From: Jonathan Best <Jonathan.Best@arun.gov.uk>
Sent: 11 October 2024 15:06
To: Planning.Responses <Planning.Responses@arun.gov.uk>
Cc: Kathryn Welch <Kathryn.Welch@arun.gov.uk>
Subject: LU/246/24/PL

Land at Toddington Lane Littlehampton BN17 7PN.

I have reviewed this application with regards to ecology and Biodiversity Net Gain.

**Figure 1.** Proposed landscaping plan for the development at Land at Toddington Lane, reproduced from Studio gb, dated September 2024 (drawing no. TLN-SGB-00-GF-DR-L-101).

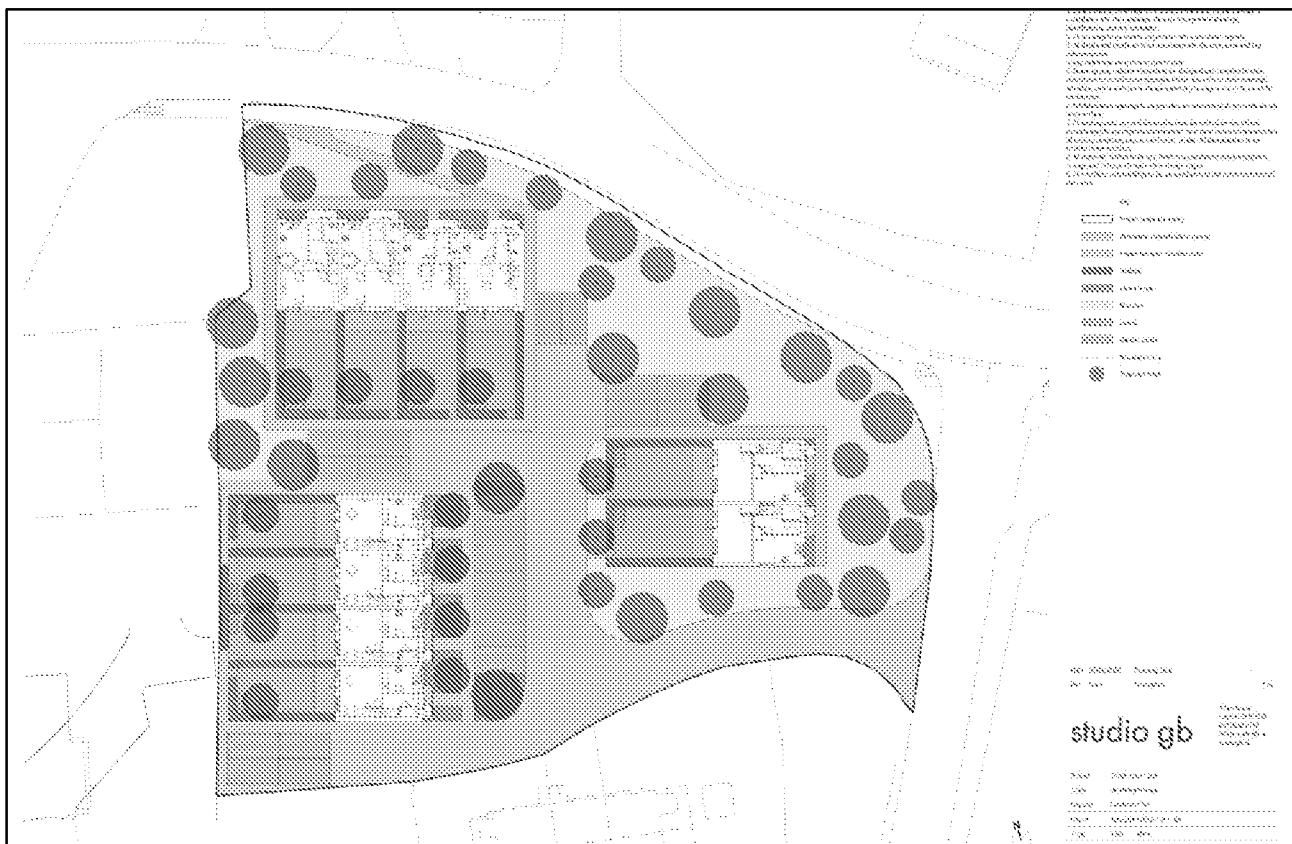
Currently no onsite habitat is being retained. Options should be explored to see if the shortfall can be achieved on site first. This is consistent with the principle of considering biodiversity from the beginning of the development process. The proposed reptile translocation highlights this as the requirement to translocate the reptiles could be mitigated onsite by retaining some of the suitable habitat.
The hedge could be extended to run along the western boundary.
